2023/0781

Alta Vista, Lund Lane, Lundwood, Barnsley, S71 5PE

Erection of dormer, single storey rear extension, two storey porch, balcony to dwelling, garage conversion and supporting boundary wall

14 PROPOSED REAR ELEVATION
1 : 50

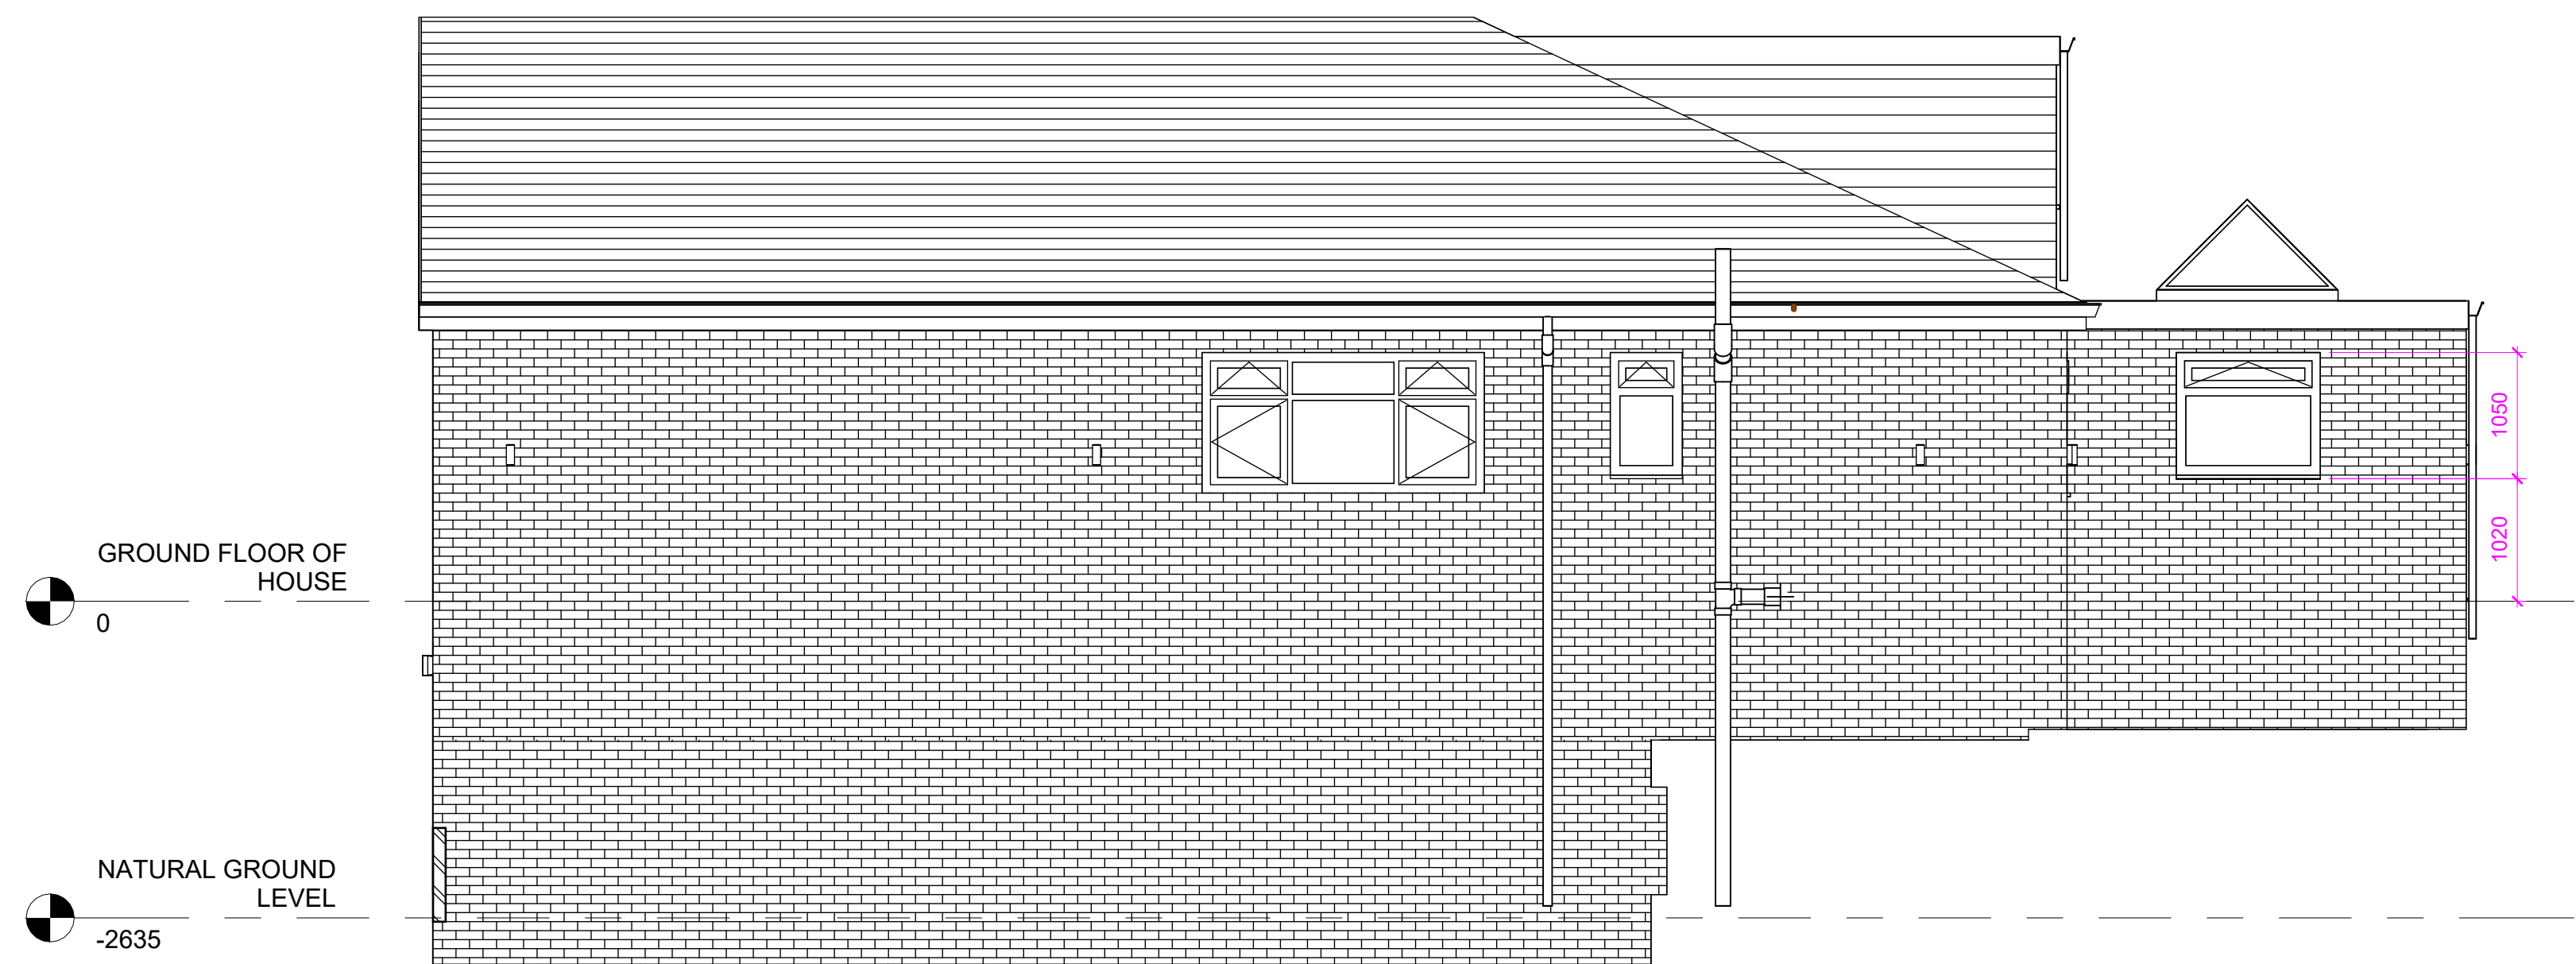
The SPD states that '*materials should normally be of the same type, colour and texture to the existing house or as close a match as possible*'. In this case, the majority of the proposed materials will be matching brickwork and roof tiles with the addition of some black cladding. This cladding is not deemed harmful as it will not be overly present on the front elevation. Also, all the dwellings on Lund Lane are individual and feature a range of contrasting materials therefore the proposed materials will not be harmful to the street scene of Lund Lane.

In terms of roof types, the front extension utilises a pitched roof which harmonises with that of the existing dwelling's pitched roof. On the other hand, to the rear a flat roof extension and dormer are proposed. Although flat roofs are usually not a supported roof type due to flat roofs being an inferior form of construction in this circumstance, they are acceptable as the dwelling is in essence single storey to the rear and they won't be visible from public vantage points or the street scene.

TITLE  
BUNGALOW RENOVATIONS  
PROPOSED FLOOR PLANS

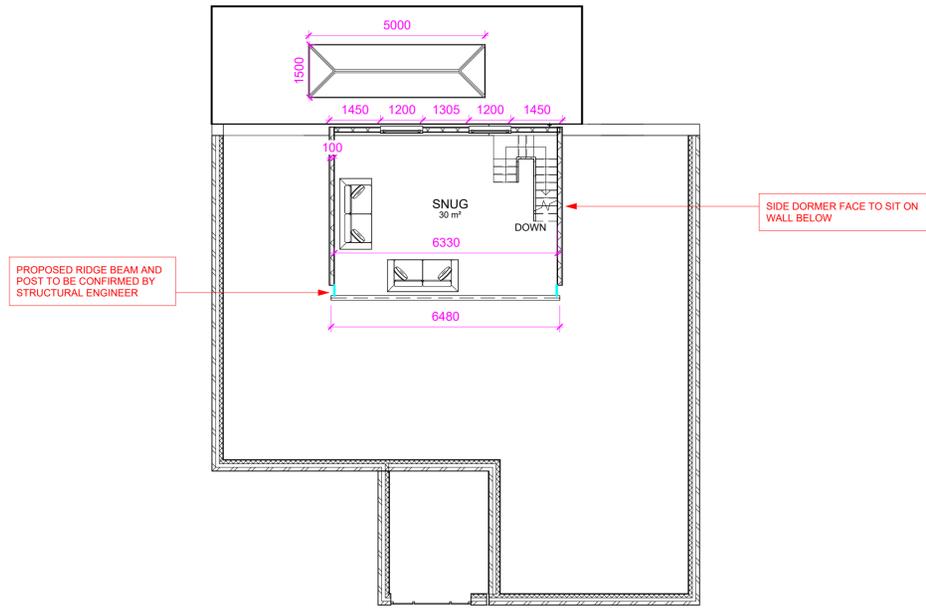
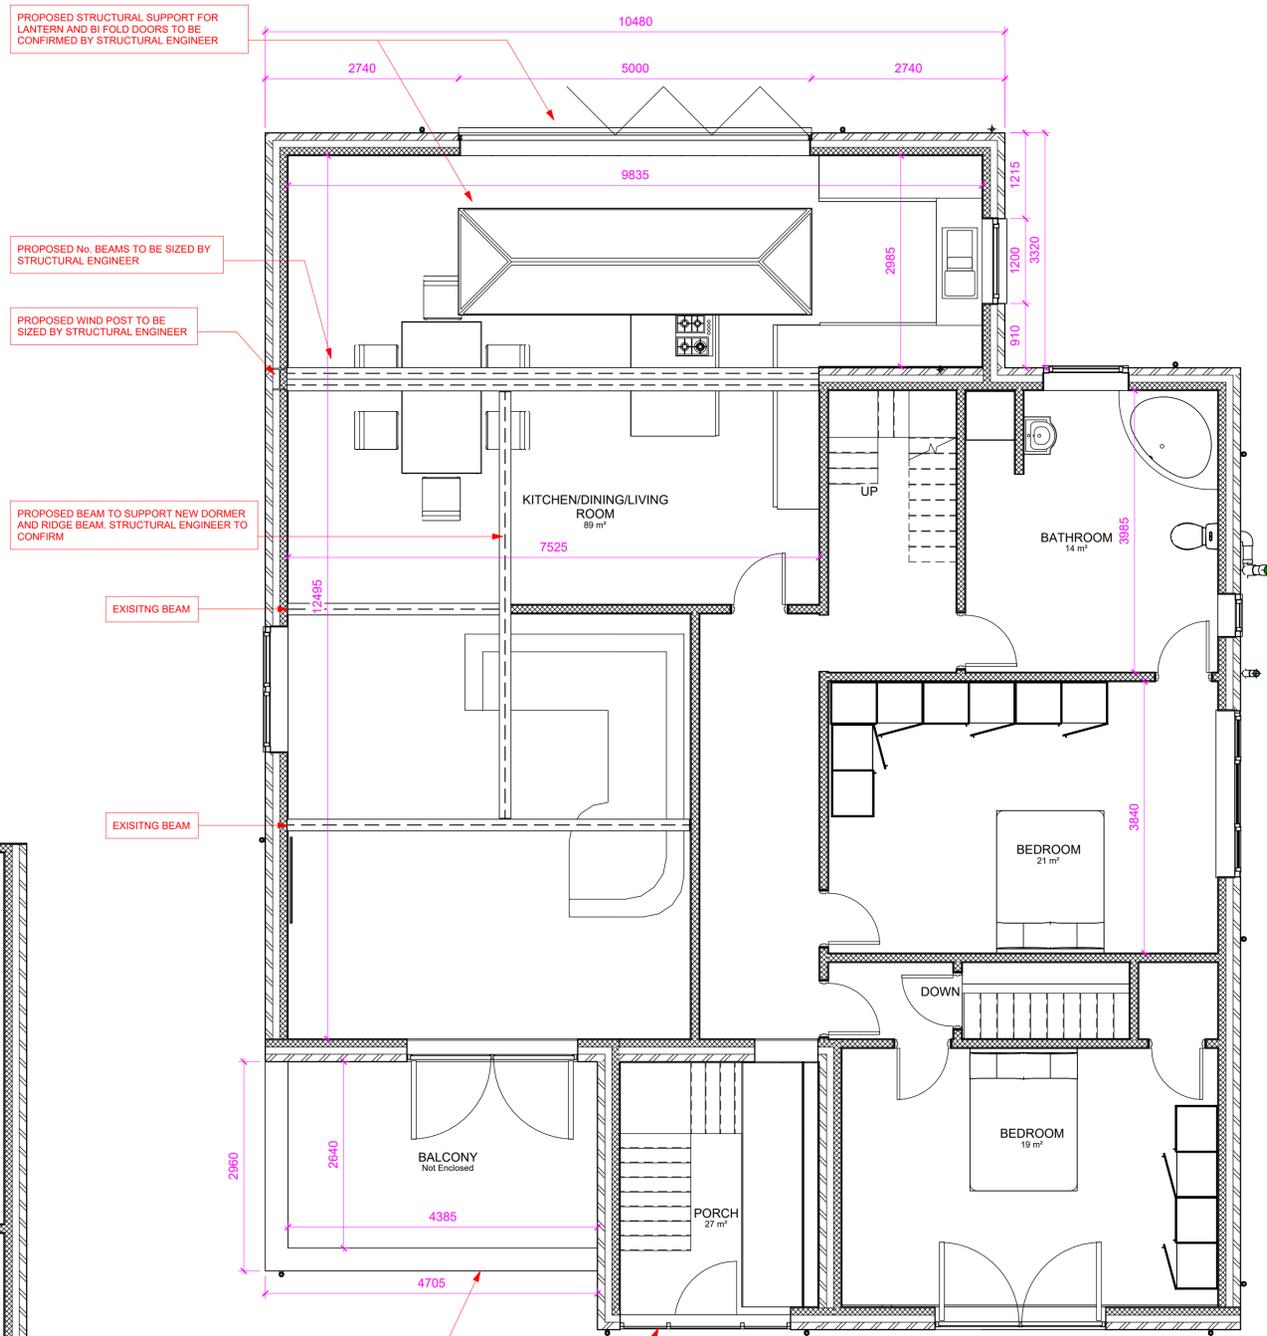
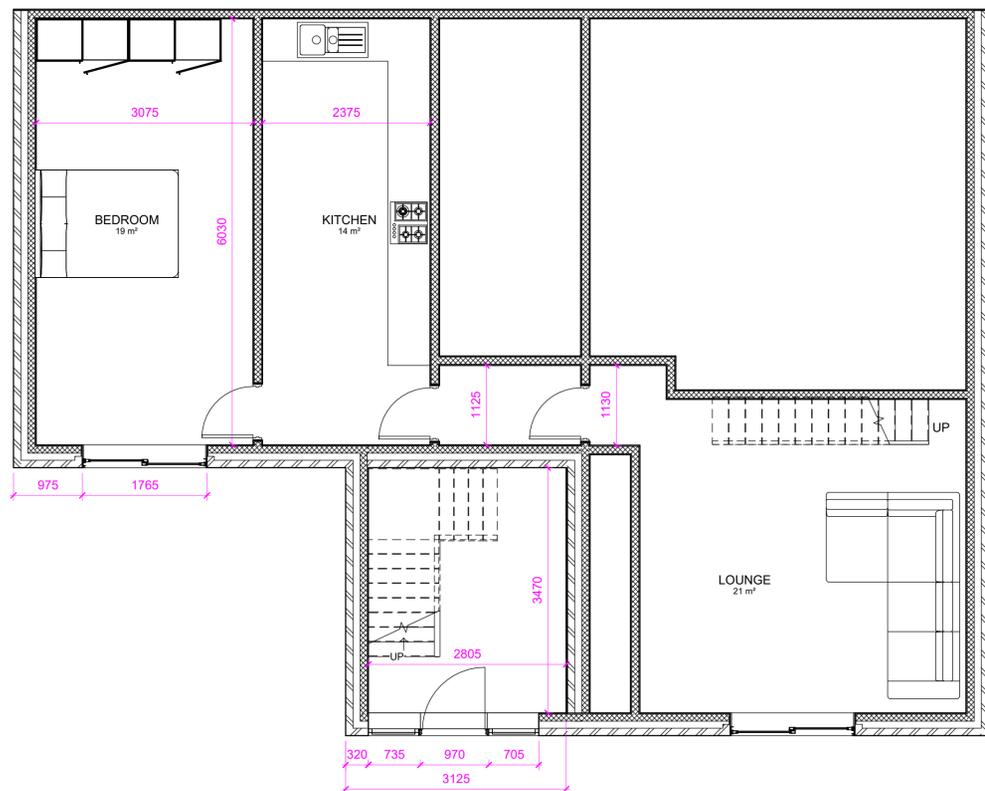
No objections were received from the neighbouring properties. The proposed front extension will not have a significant detrimental impact on any neighbouring property by way of overshadowing or being overbearing. The proposed front extension will not project further than the existing front elevation of the dwelling. In terms of overlooking no windows are proposed on the side elevation of the front extension and the proposed glazing on the front elevation are not deemed to be harmful.

The proposed single storey rear extension will not have a significant detrimental impact on any neighbouring property by way of overshadowing or being overbearing due to its limited projection of only 3.8 meters which for a detached dwelling is within the 4-meter permitted development projection limit. The height is 3.7 meters which is acceptable and balanced in relation to the rest of the rear elevation as the eaves align with that of the dwelling. In terms of overlooking the only window proposed on any side elevation of the rear extension is small and will not lead to significantly detrimental levels of overlooking of the adjacent property.

The proposed dormer window partially conforms to the requirements of the SPD given that it will be set down from the roof line and setback from the gable end however a flat roof is used. This will not have a significant impact however and although large the dormer is within the 50 cubic meter limit set by permitted development rights. There will be no impact upon residential amenity from the proposed front wall. The proposal is considered to be in compliance with Local Plan Policy GD1: General Development and is acceptable in terms of residential amenity.
